From: Gomez, Angela J.
Sent: Tuesday, August 04, 2020 2:16 PM
To: Gomez, Angela J.
Subject: FW: [#2020013] Wintergreen Apartments DRB questions (PR-2020-004030) (2)

The intent of this email is to provide responses to the questions raised by neighbors at the DRB hearing on July 22nd 2020, in regards to the proposed Wintergreen Apartment project City project number PR-2020-004030.

The updated plans to address DRB comments from the July 22nd hearing are available on the City website: http://data.cabq.gov/government/planning/DRB/PR-2020-004030/DRB%20Submittals/PR-2020-004030_Aug_5_2020_Supp/Application/DRB%20Resubmittal%207.31.2020/2020013%20DRB%20Plans%20-%20Wintergreen%20Luxury%20Apartments%20Resubmittal%207.31.2020.pdf

Z:\2020\2020013_Apartments at Golf Course Rd.dwg Base E:\2020013_Building C & D Cross Section_Exhibit_B.dwg Jul 30, 2020 - 2:44pm

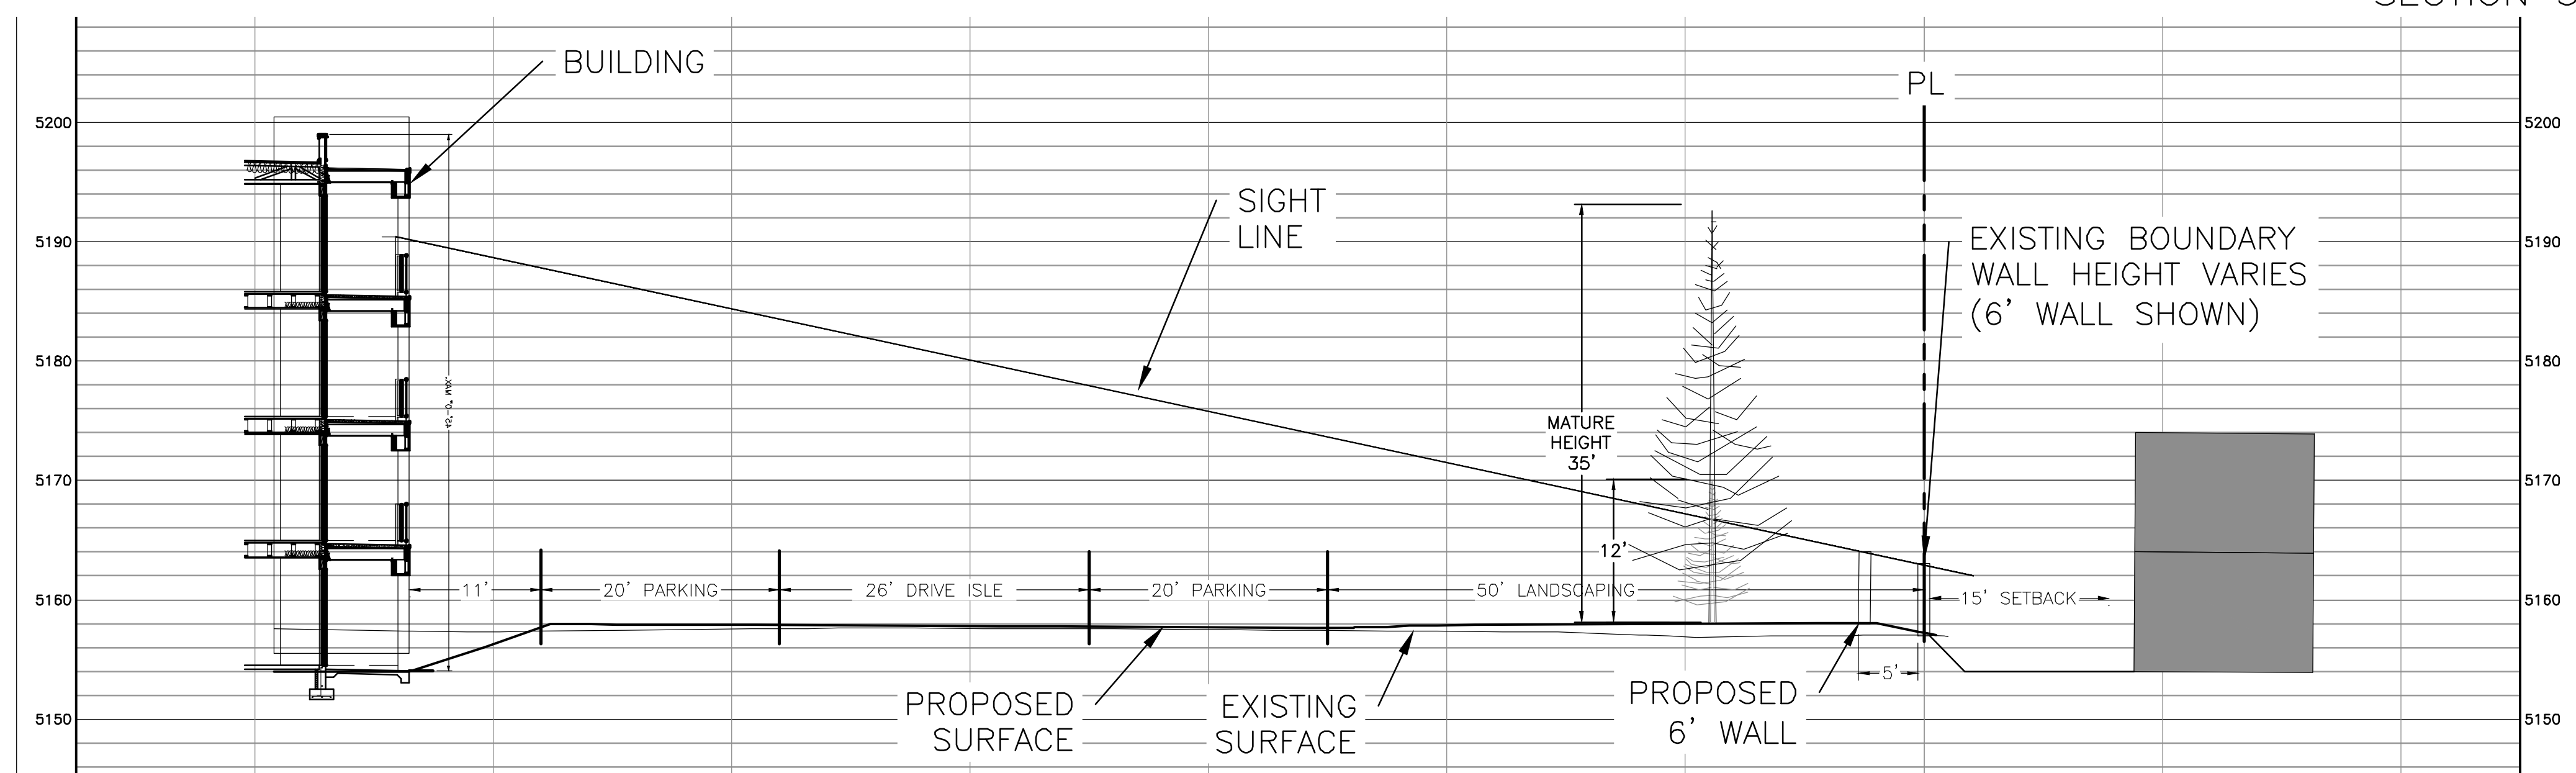
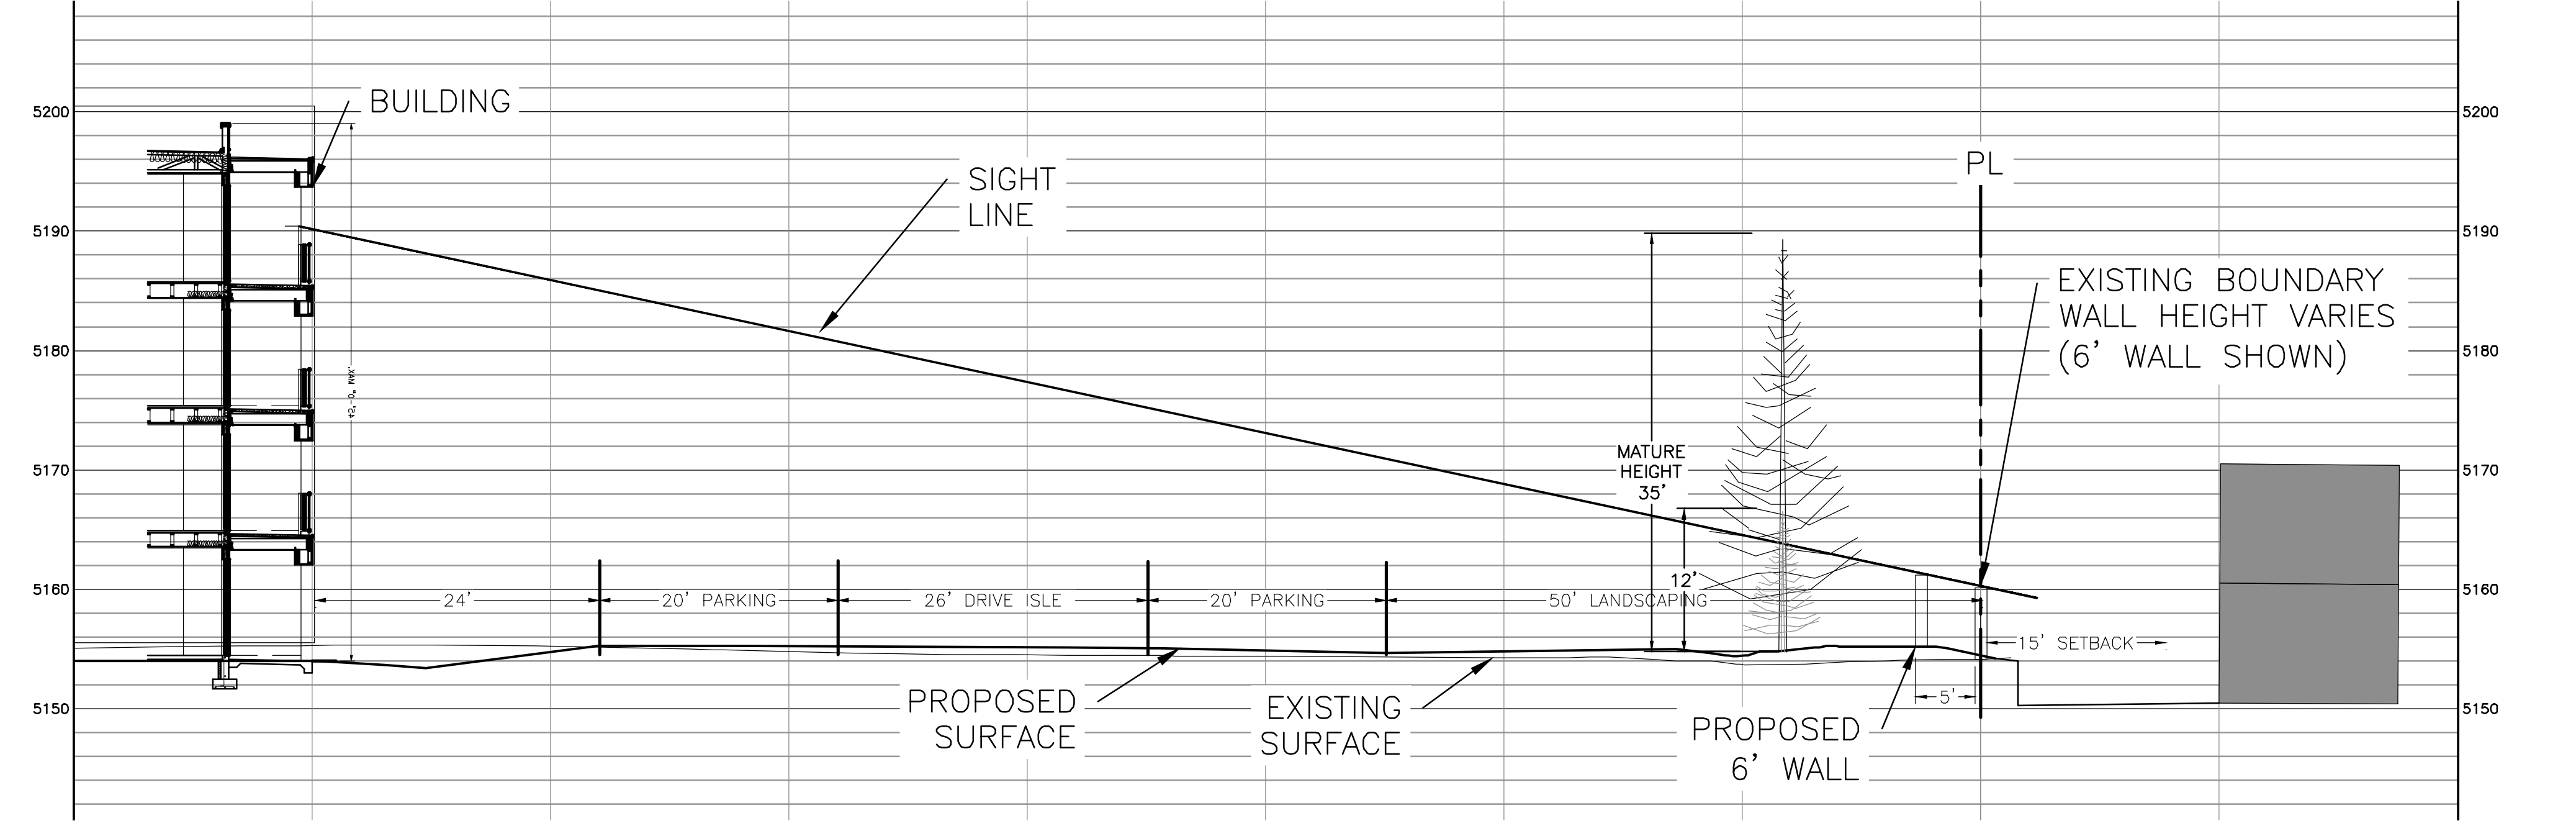
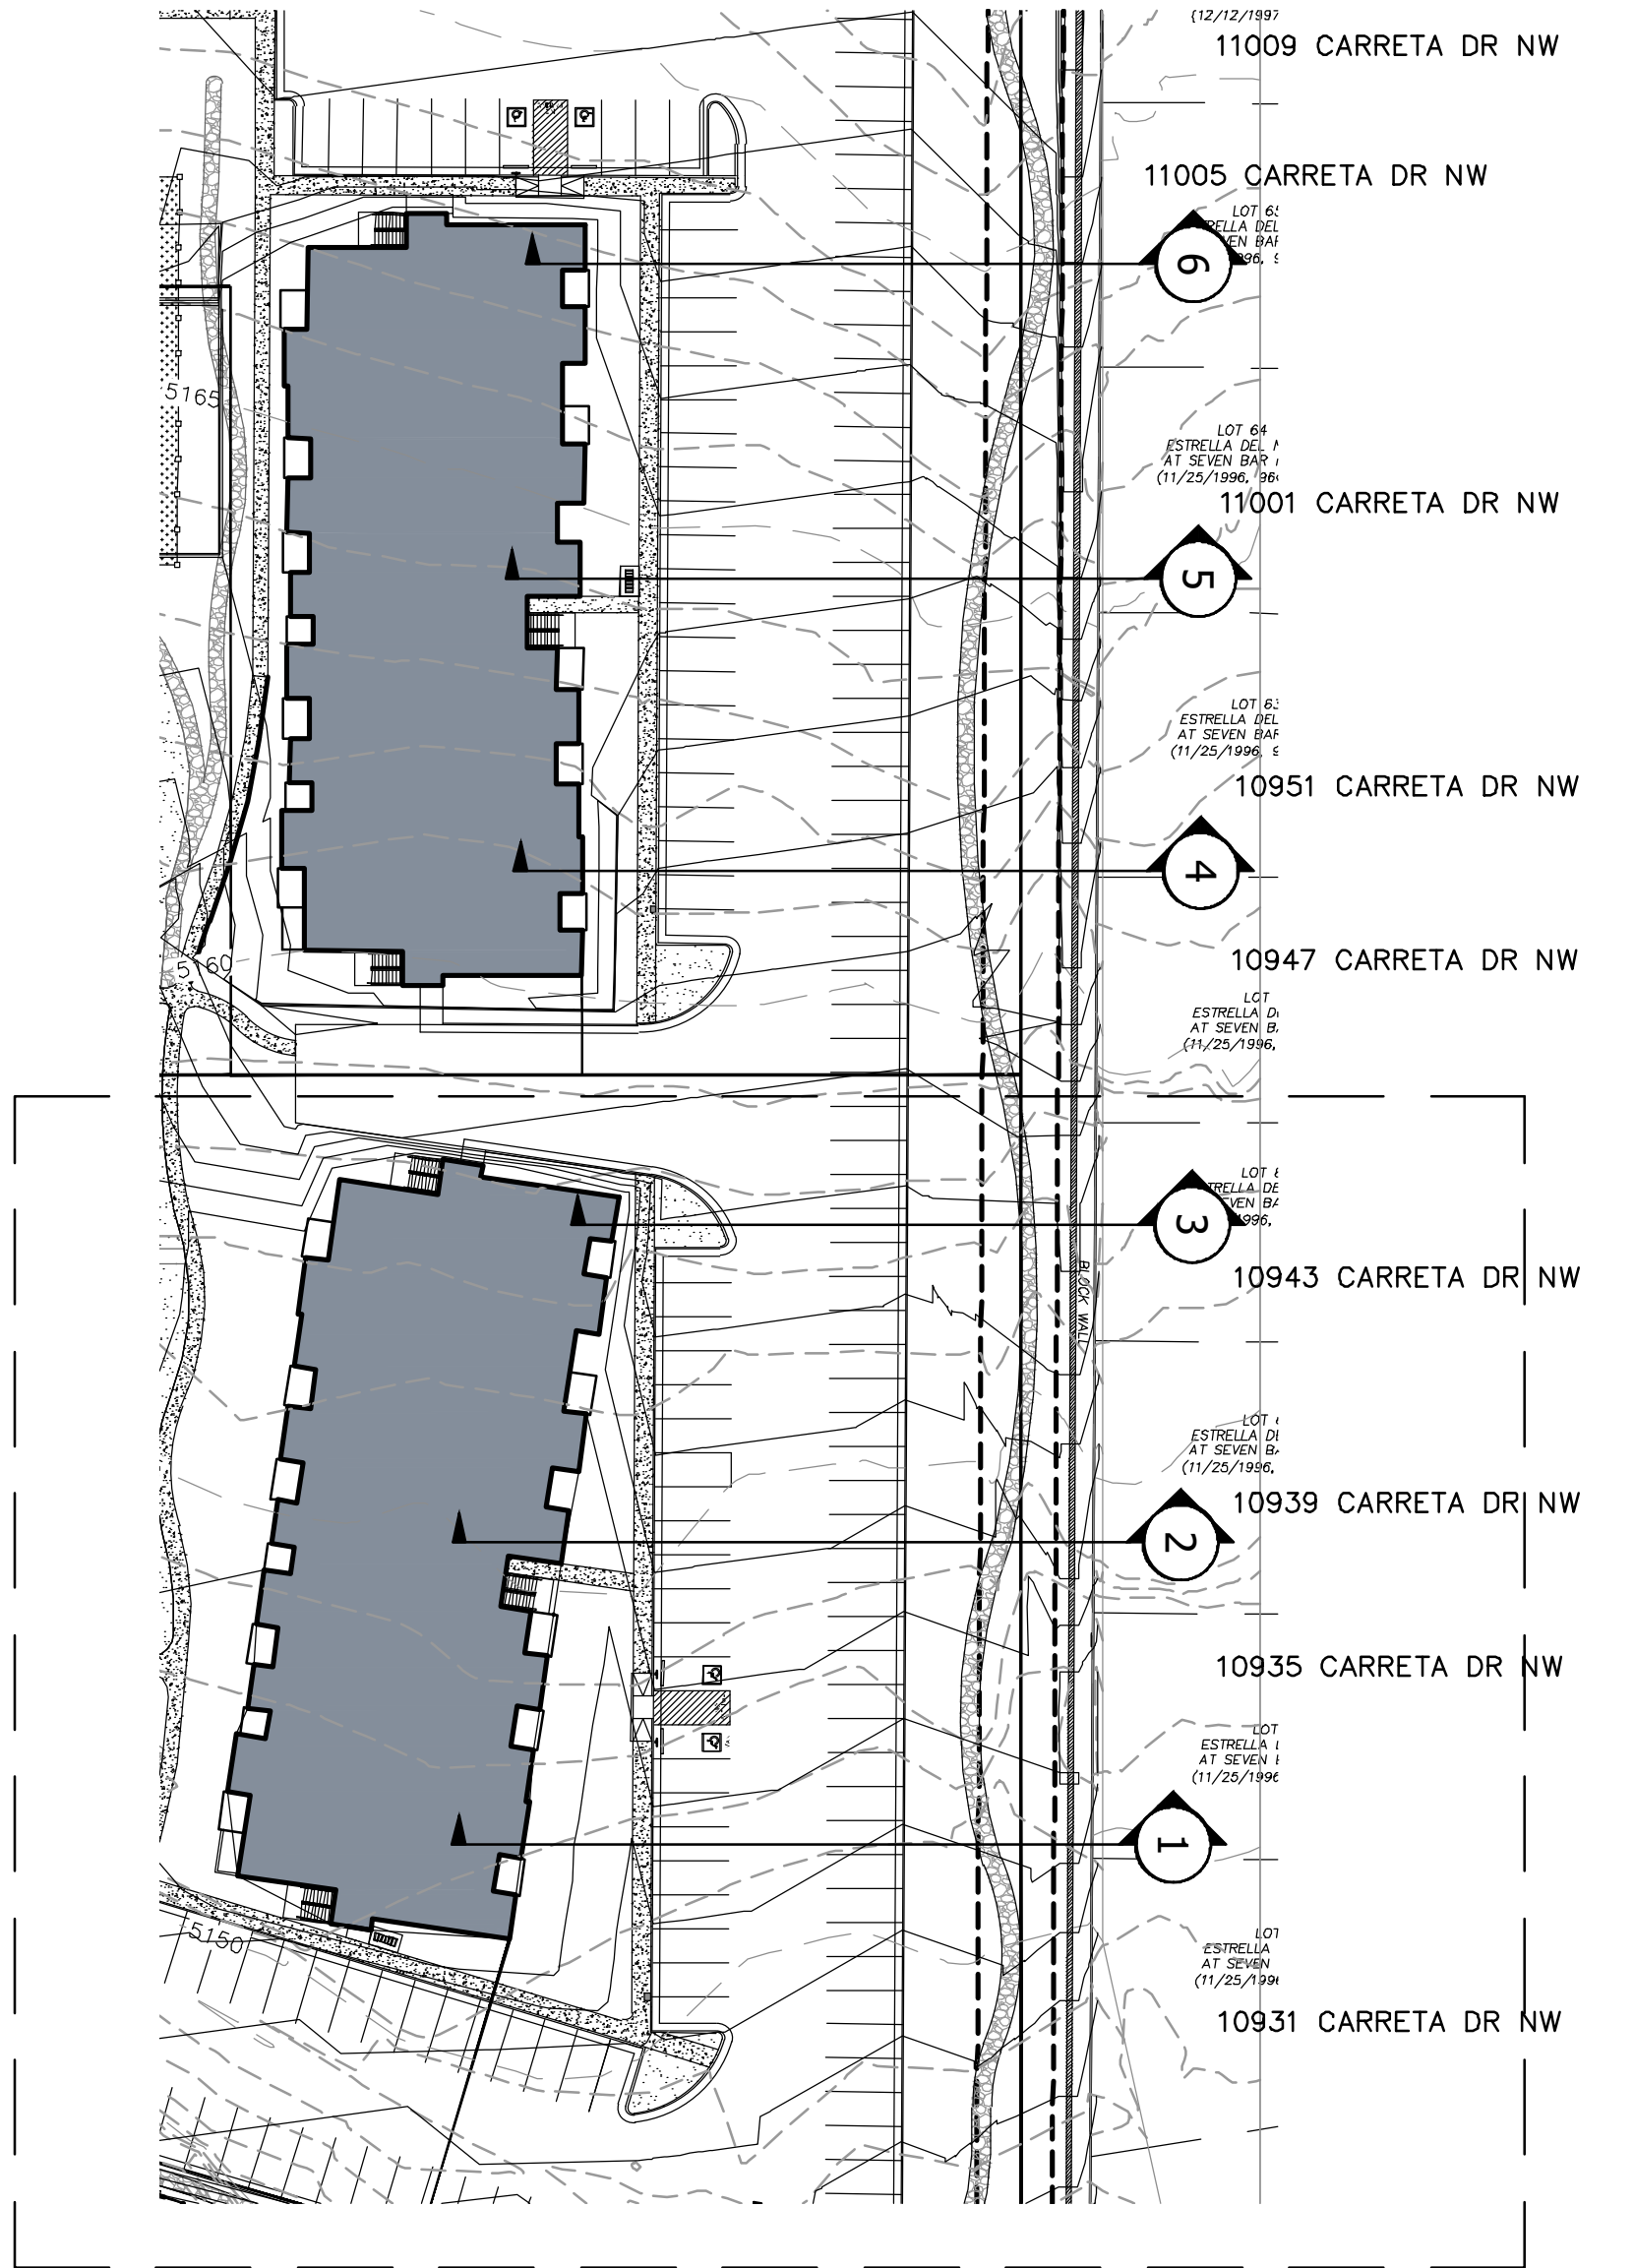
7. The cross-sections provided are inadequate when speaking to the privacy and noise barriers needed for the residents. Cross-sections show trees. Where exactly are they planted, spacing, heights, etc. We have no clear view of what will be in the buffer and how it will protect the adjacent property owners.

The tree sizes at planting and at maturity are shown in the cross sections to provide a scale and orientation of the apartment building relative to the single family homes and detail the buffer area. As previously mentioned the IDO requires a 50-ft landscape buffer (IDO Section 5-9(F)) to provide a setback between the improvements and the single family homes to increase the privacy and to reduce sight-lines from adjoining properties. Based on the proposed building height there is also a minimum 100-ft offset from the property line (IDO Section 2-4(C)), to provide protection to the adjacent home owners. Please refer to the landscaping plan which details the tree spacing, heights at maturity etc. which is included in the plans (link provided in previous email).

Response: A view plan exhibit was prepared to show the sections along the east half of the property and is attached to this email.
